**Addendum No. 1**

RE: Contract # C204684

**Haywood County (B-3186, B-5898)**

BRIDGES #155 AND 158 OVER RICHLAND CREEK ON US-23/74 AND  
BRIDGE #168 OVER US-19 AND US-23 ON US-23/74.

REVISIONS

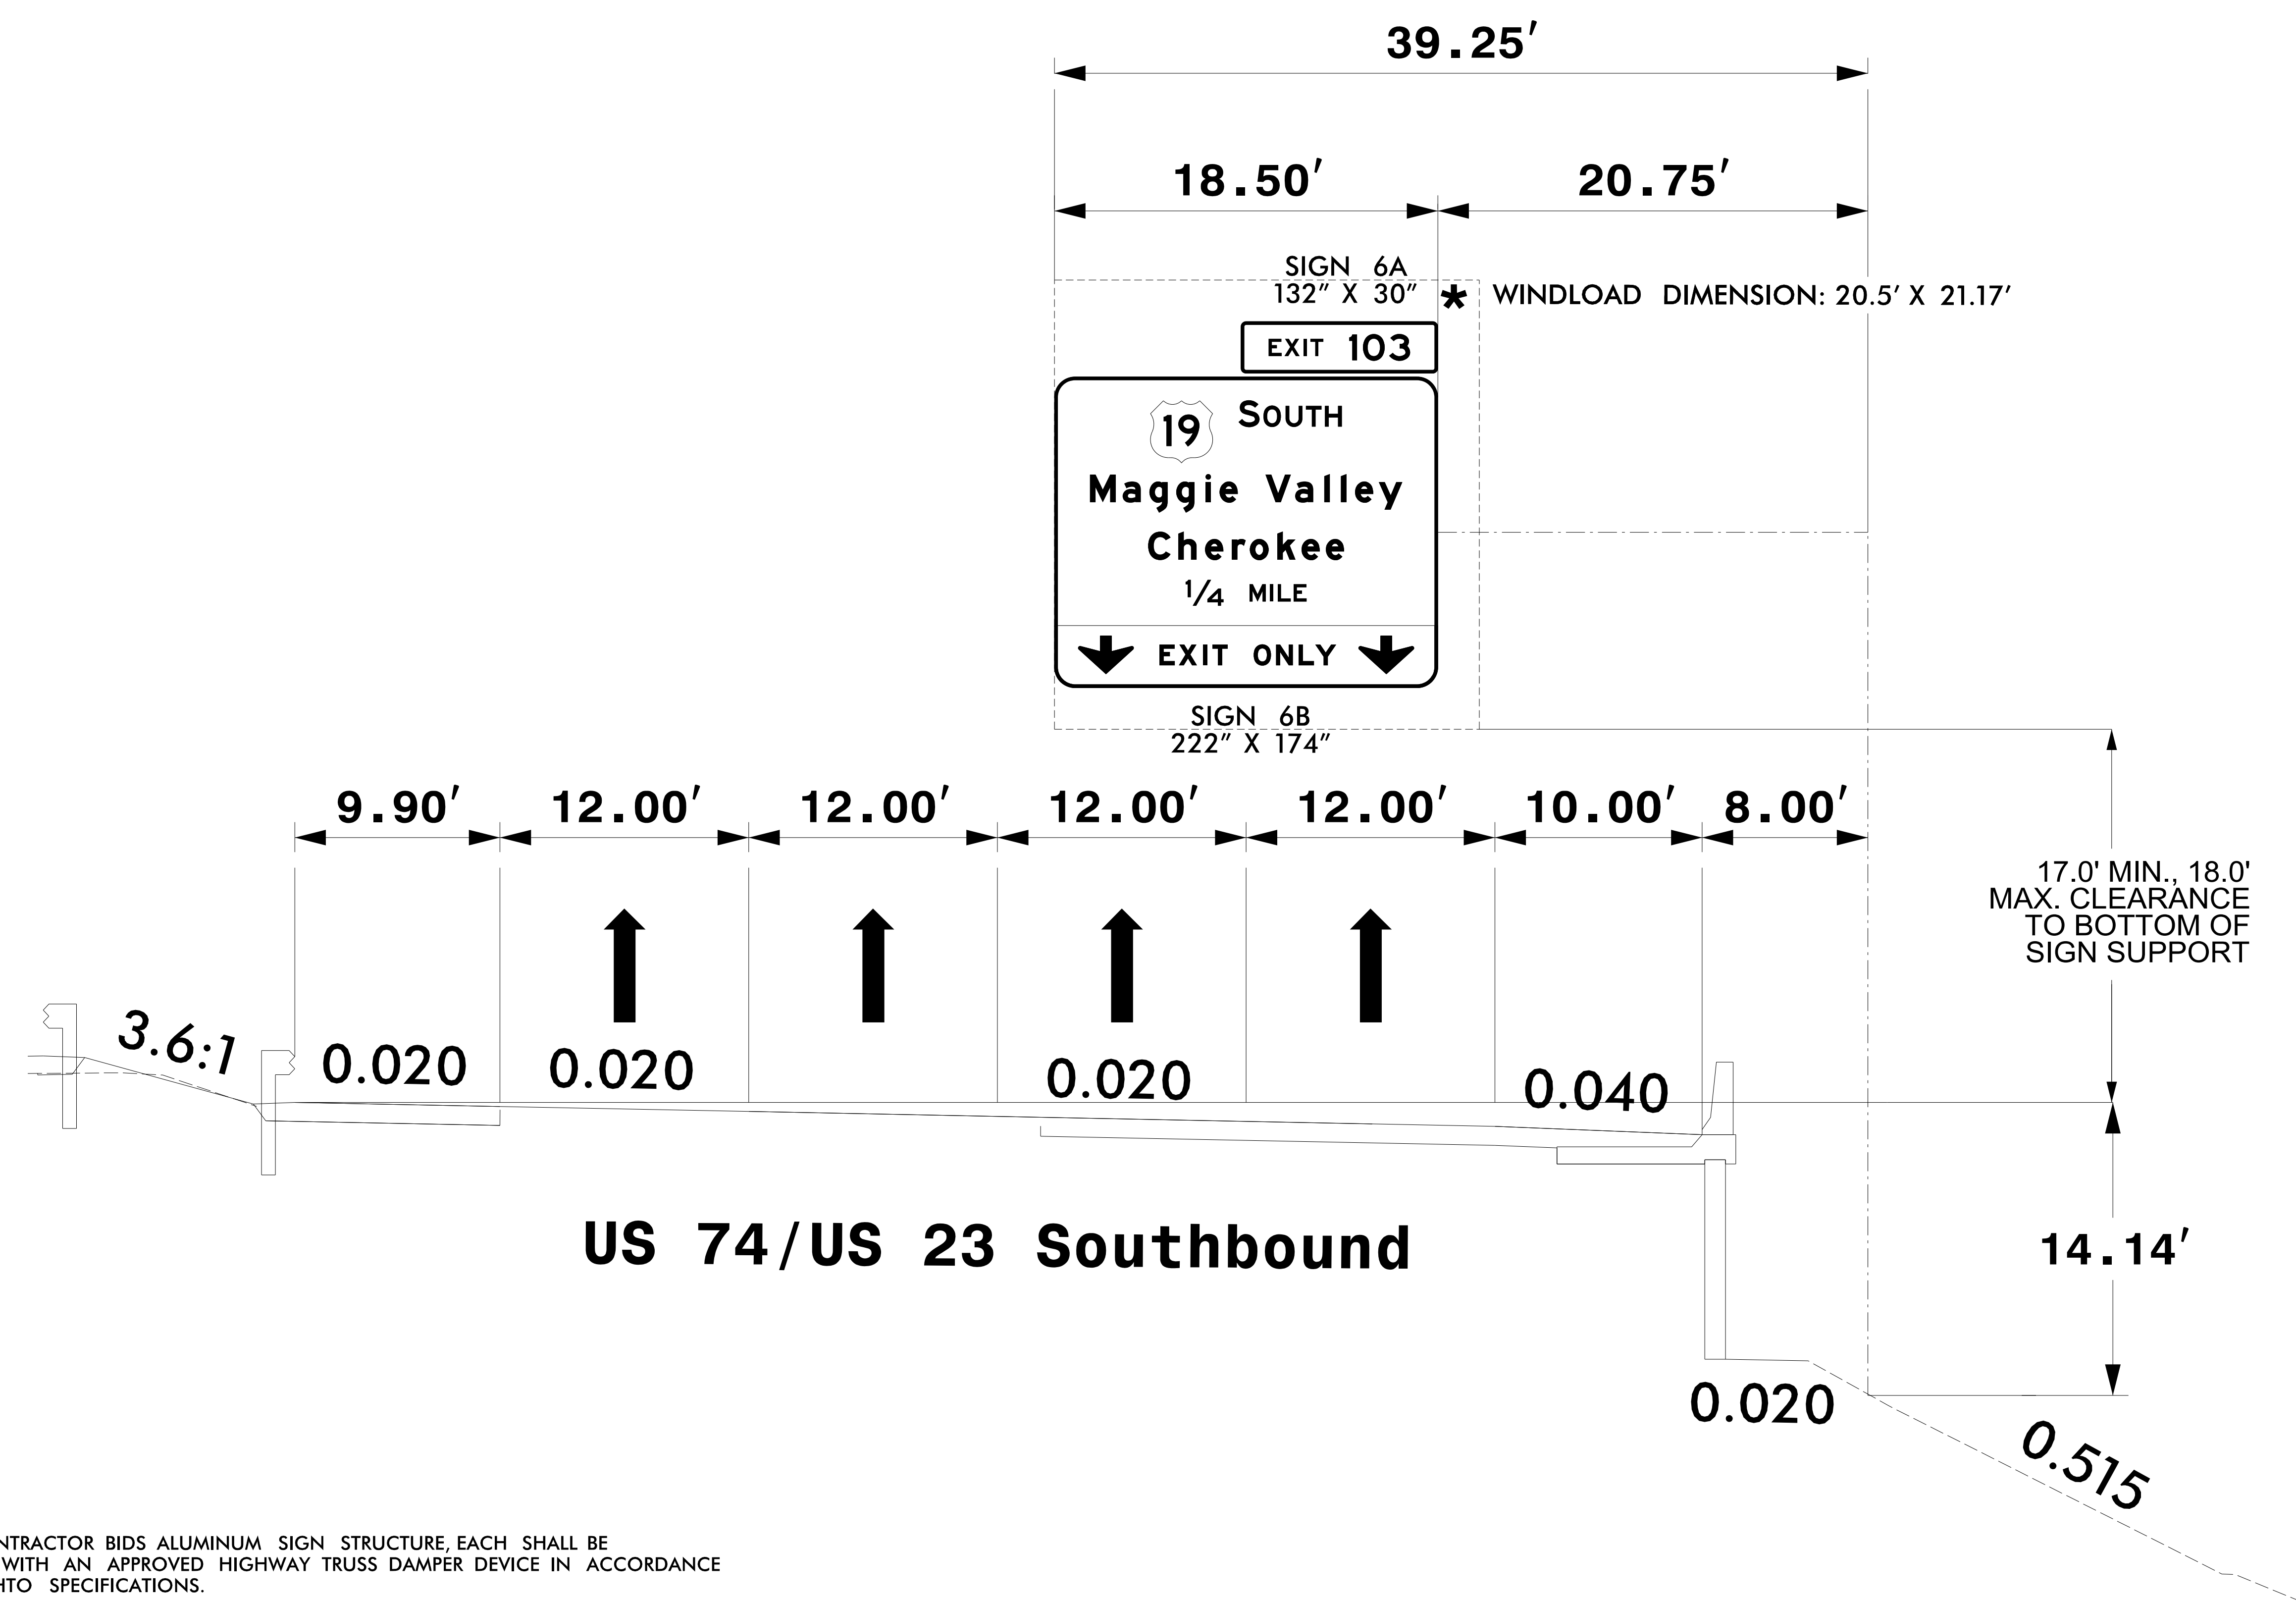
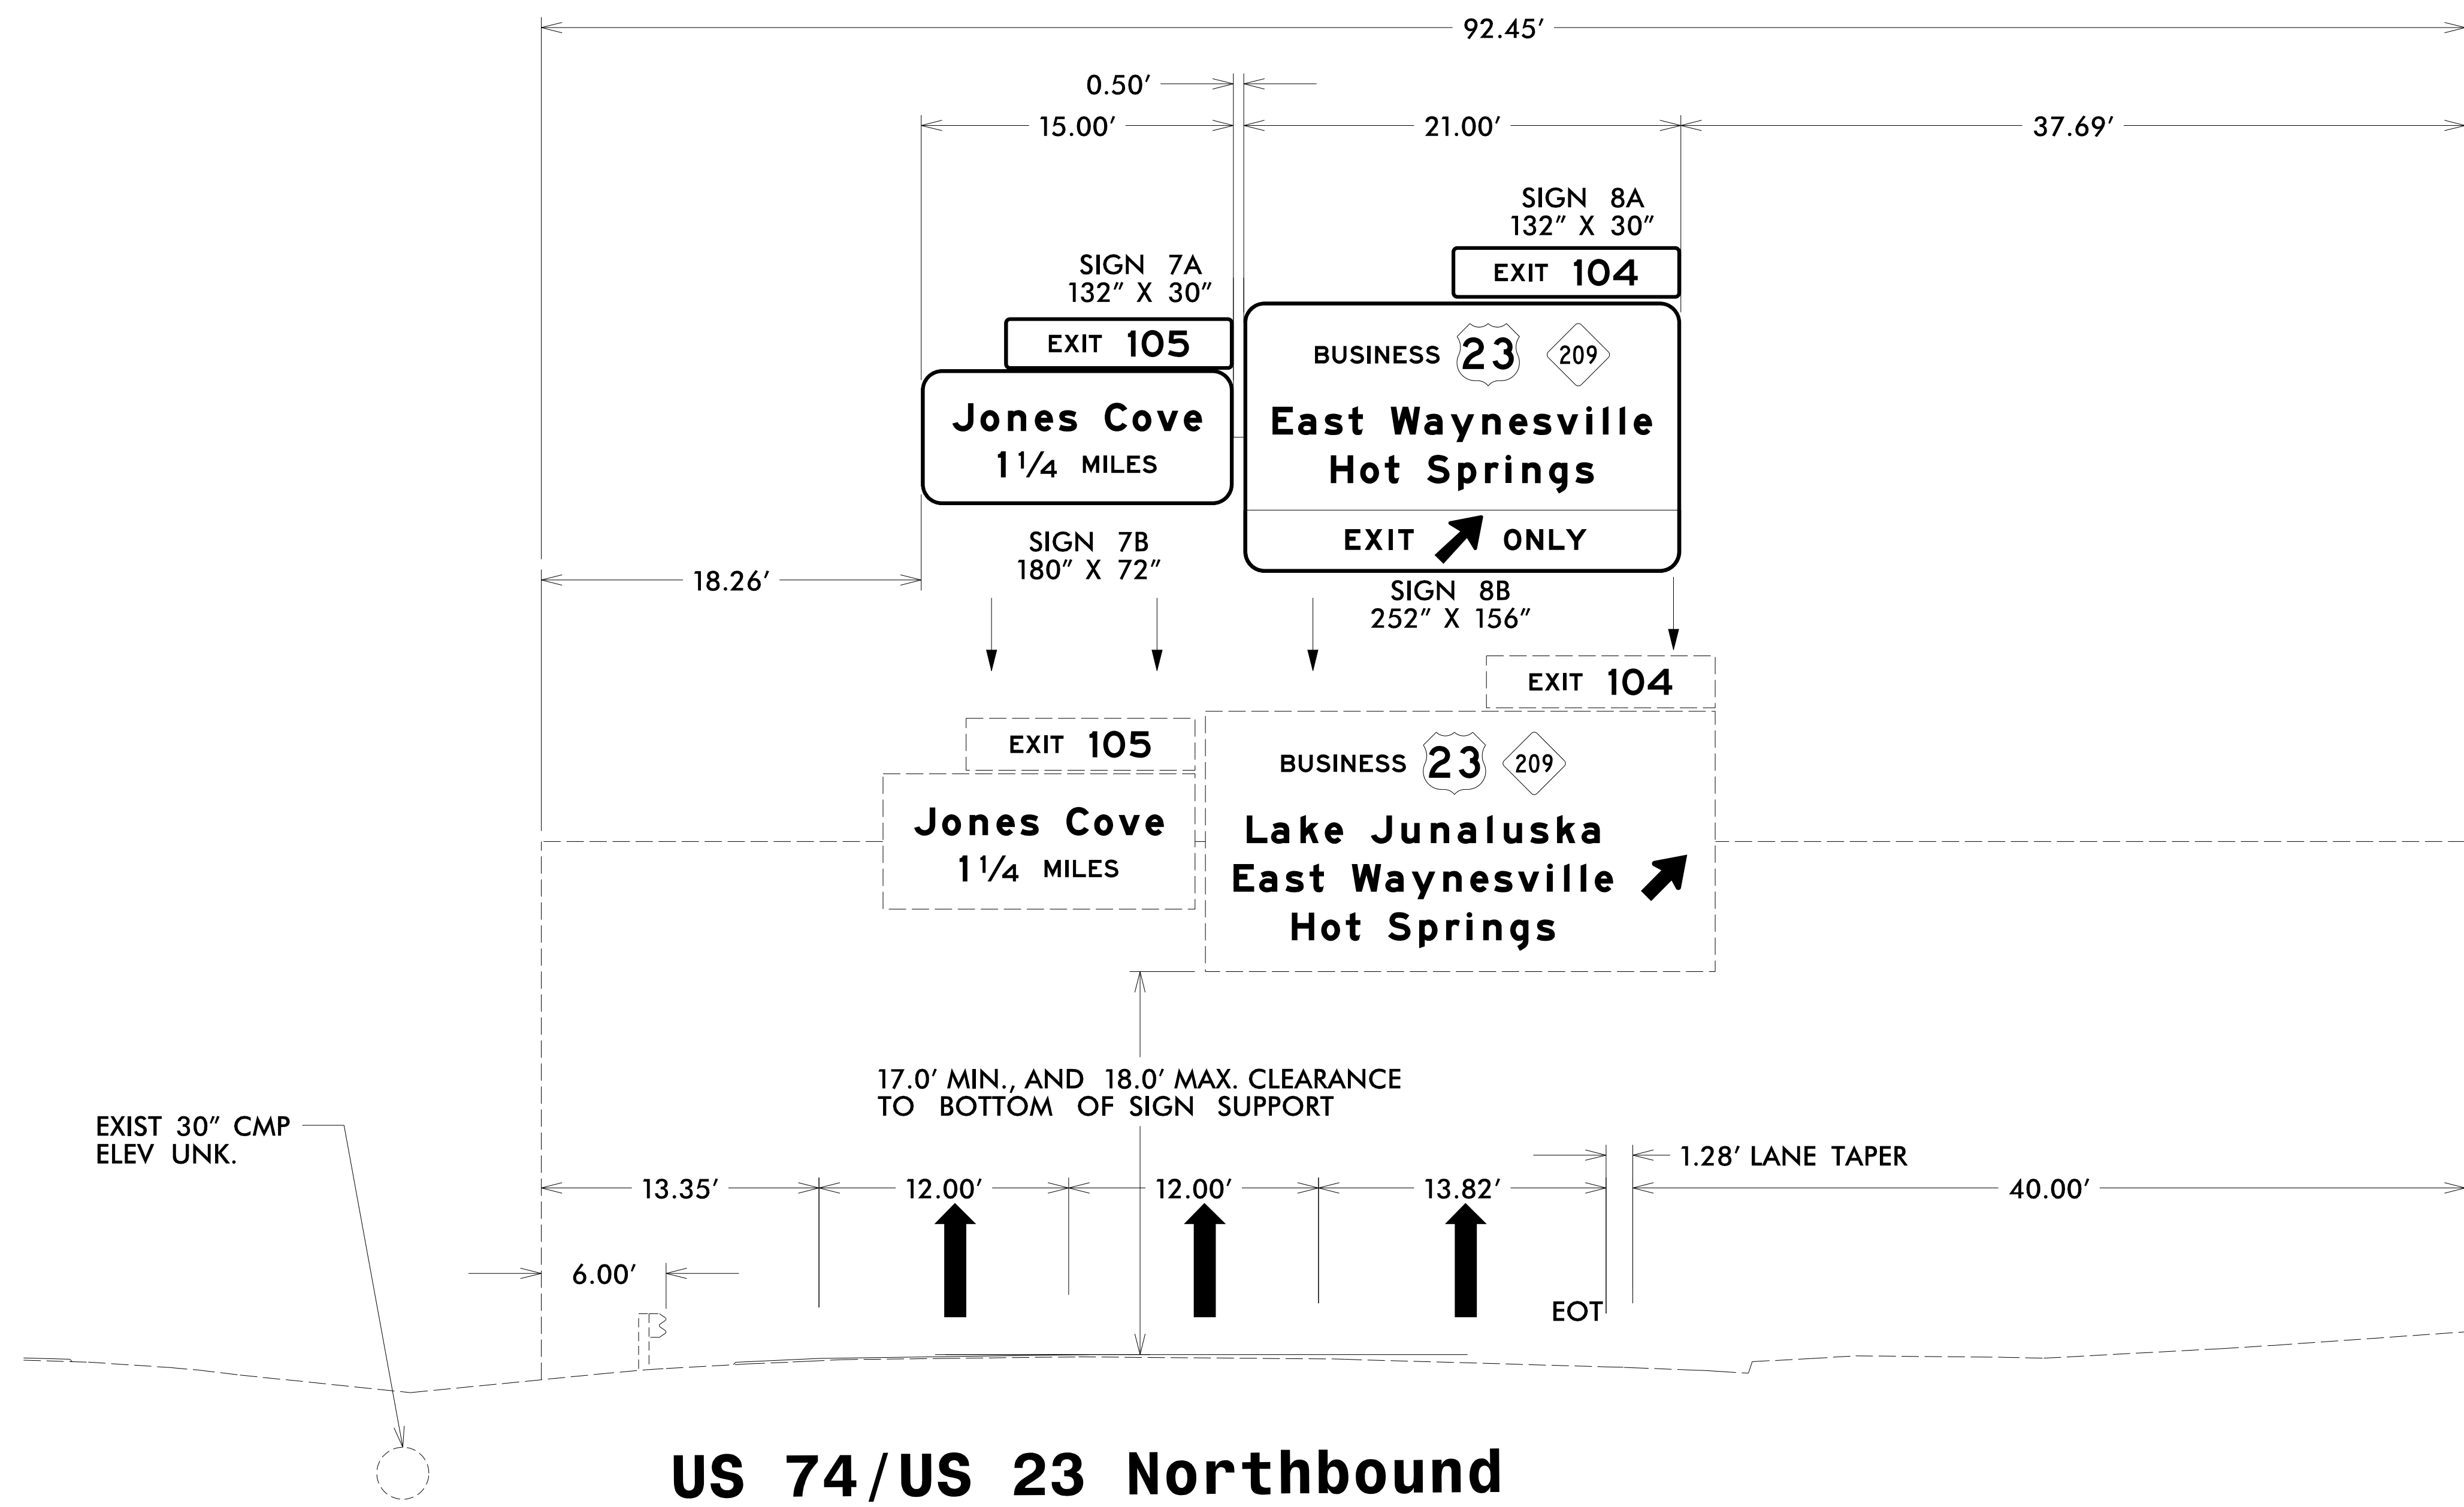
Sheet No.	Revision
SIGN-1	Quantities revised, removal of plan submittal block, and Roadway Standard Drawing list updated.
SIGN-2	Overhead Sign Assembly dimensions revised.
SIGN-2A	Existing Sign identifier numbers added, sizes revised.
SIGN-3 thru SIGN-5	Font, symbol, and panel sizes revised in sign designs. Milemarker signs clarified. Some signs modified to freeway sign size standards.
SIGN-6 thru SIGN-9	Added route labels and cardinal directions to roadways, revised project notes, and corrected sign number labels.
